Your ref: Sofia Offshore Windfarm
and Doggerbank Teeside A
Date: 29 July 2020

SOFIA OFFSHORE WINDFARM AND DOGGERBANK TEESIDE A

Environment Agency Position

Appendix A-2 – Wilton cable works 1: Drawing showing area identified by grid coordinates in Table 2 of DCO Requirements 1 and 19

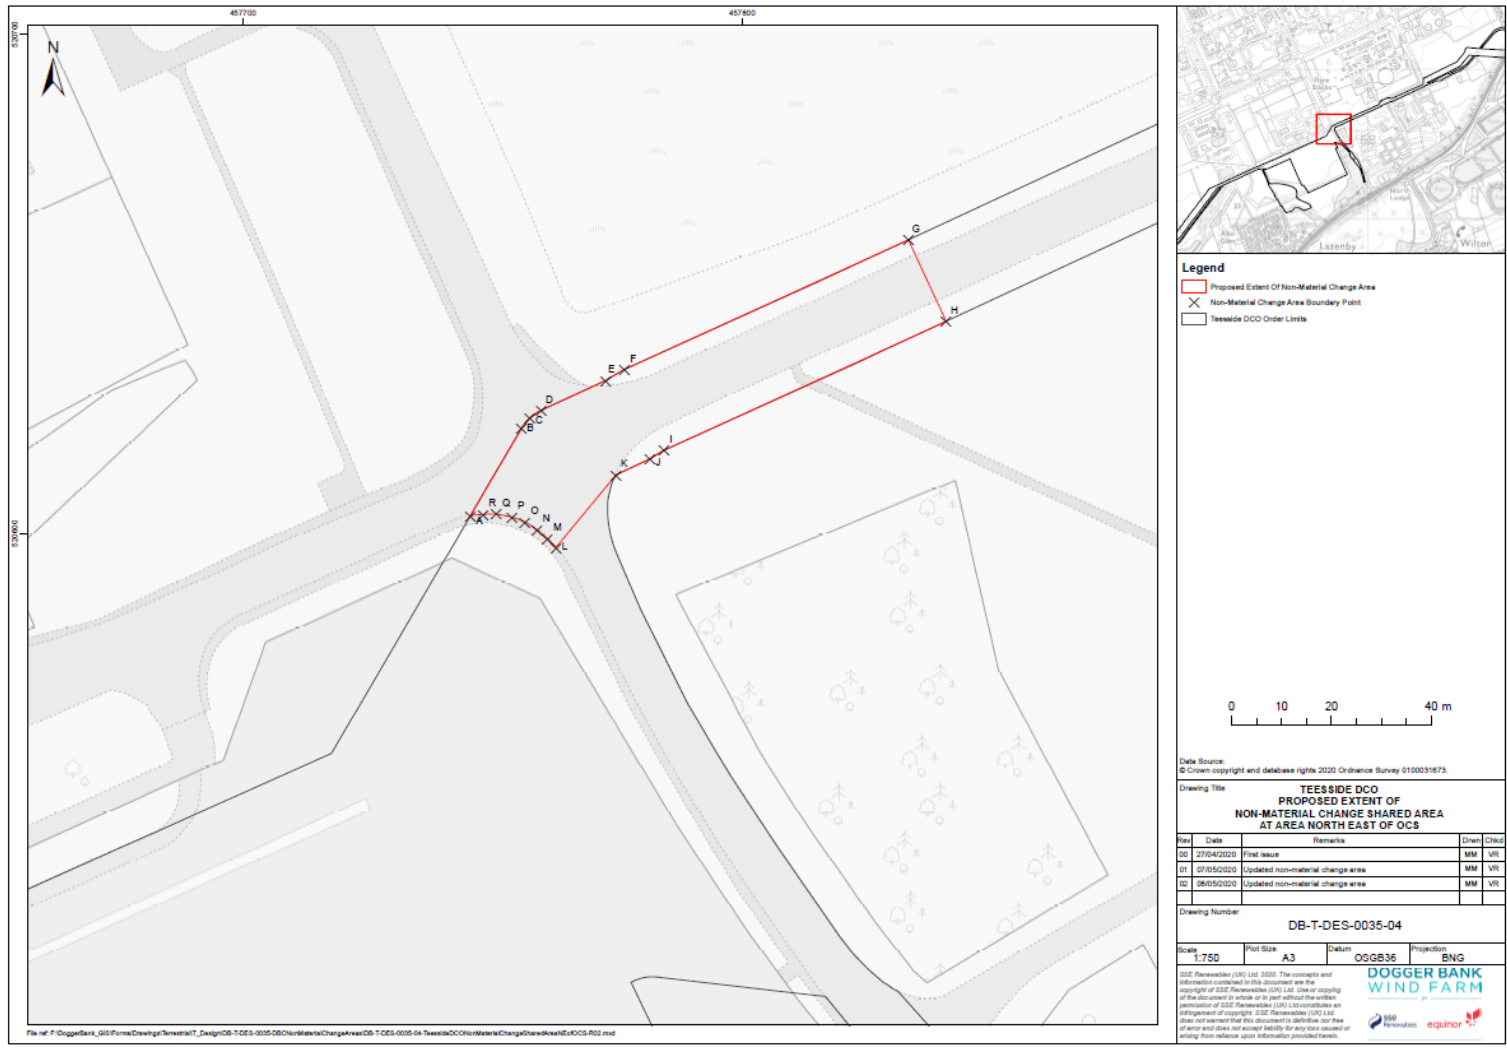
With respect to cabling works at grid reference NZ5654519768, it should be noted that the proposed works is situated on or next to a closed authorised landfill site, regulated by the Environment Agency.

Based on the information submitted, it is unclear whether the proposed open trenches are located on top of this closed landfill site. Development on top of or within 50 metres of any permitted landfill site that accepted hazardous or non-hazardous waste should be considered very carefully, as even with appropriate building control measures in place, landfill gas can accumulate in confined spaces and can gain access to service pipes and drains where it can accumulate or migrate away from the site. You should consider the potential risk to the development from landfill gas, ensuring that appropriate assessments have been carried out to identify potential risks. Where risks are identified you should ensure that any threats from landfill gas have been adequately addressed in the proposed development.

Attached is a plan showing the landfill gas boreholes on the perimeter mounds closest to the proposed works. The borehole must not be damaged in any excavation work in this area. The latest monitoring results (from 2004) do not indicate the presence of landfill gas.
